AL/23/13/WMA

Application for a non-material amendment following a grant of planning permission.

DEMOLITION OF EXISTING GARAGE AND LEAN TO EXTENSION - ERECTION OF A NEW SINGLE STOREY EXTENSION AND GARAGE AND ASSOCIATED EXTERNAL + LANDSCAPING WORKS.

GARAGE MOVED EASTWARDS APPROXIMATELY 450MM TO ALLOW EASIER ACCESS TO THE GARAGE.

Project & Drawing title					
PROPOSED GROUND & FIRST FLOOR PLAN & ELEVATIONS					
Drawn	Date	Checked	Date	Scale	at A1
NKS	07/11/12	MHA	14/11/12	1:100	
Job N°	12-115	Drawing N°	PL 05	Rev.	B
Status	PLANNING

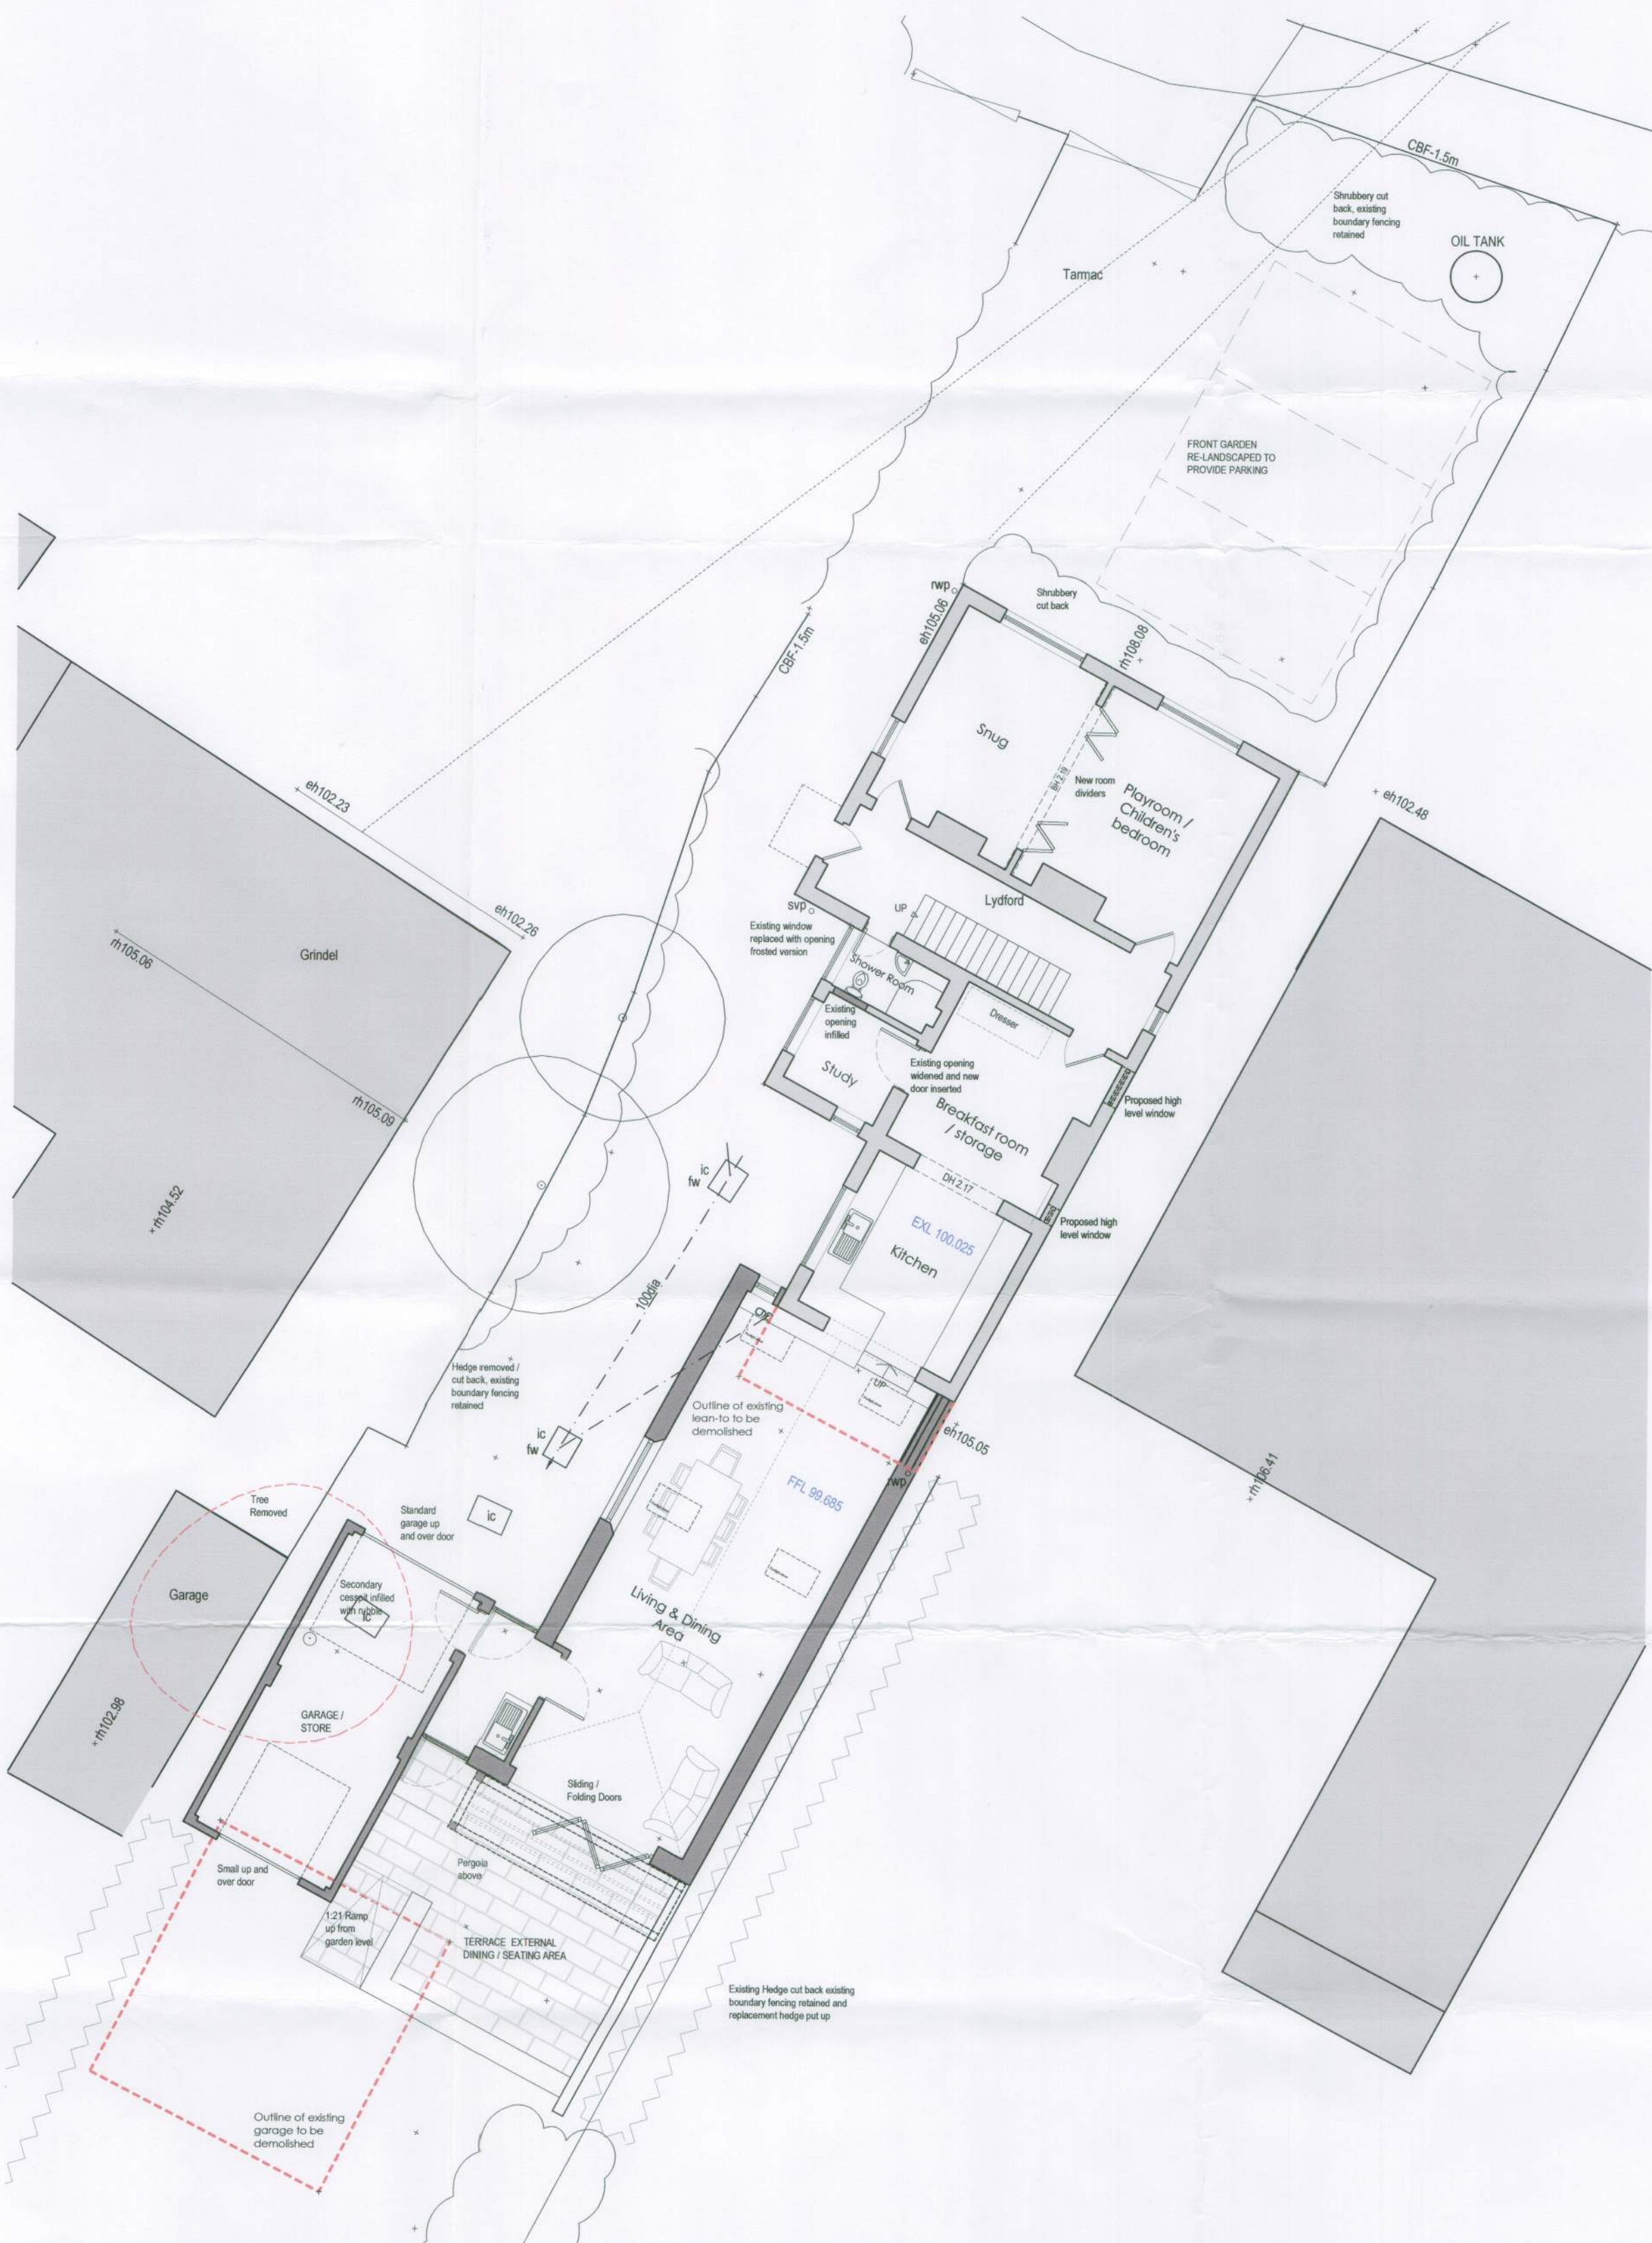
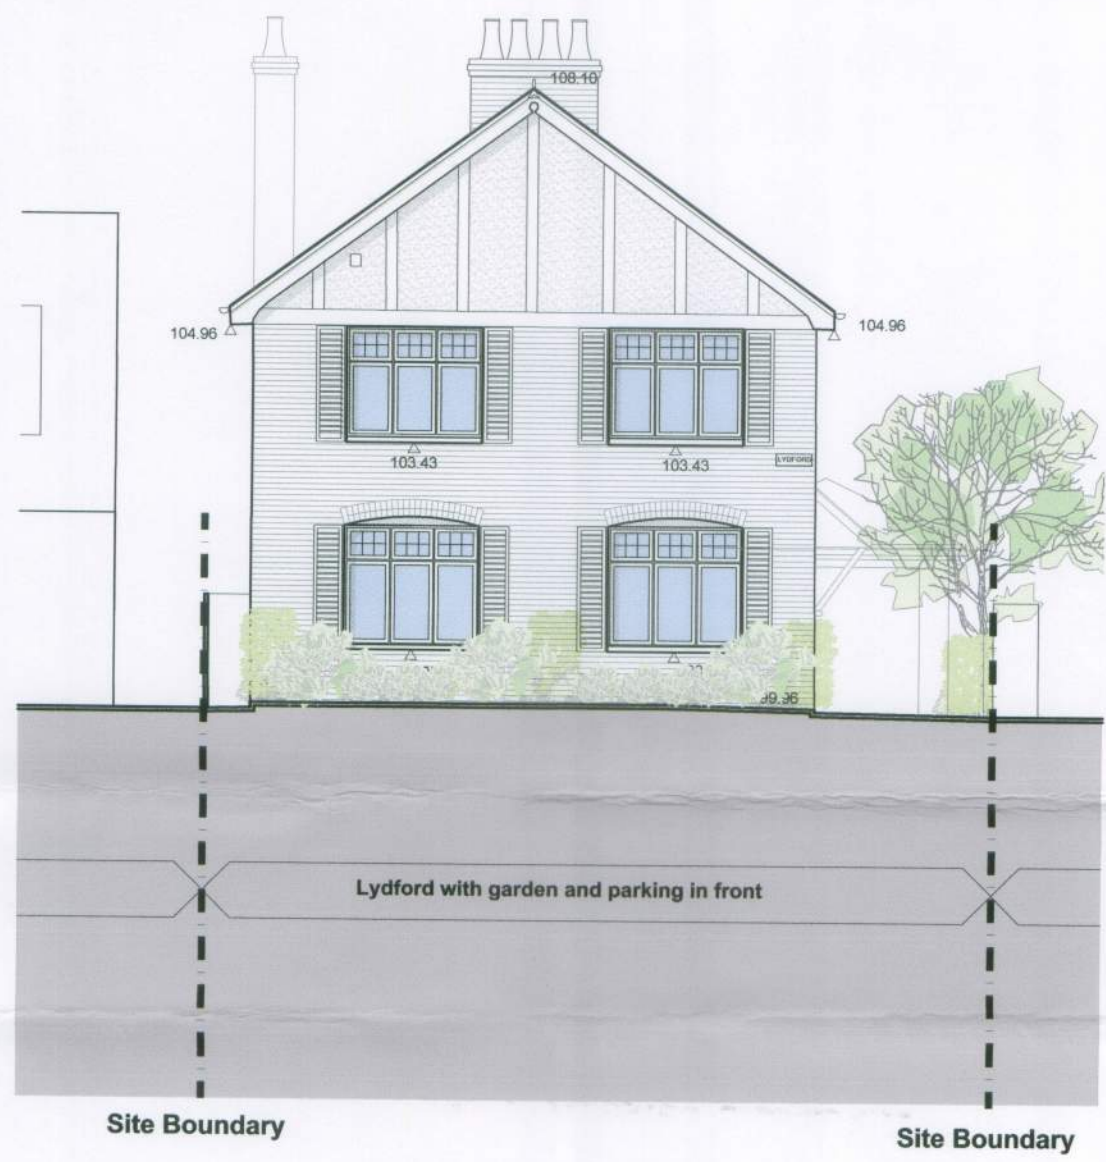
IMPROVE ACCESS INTO THE GARAGE.
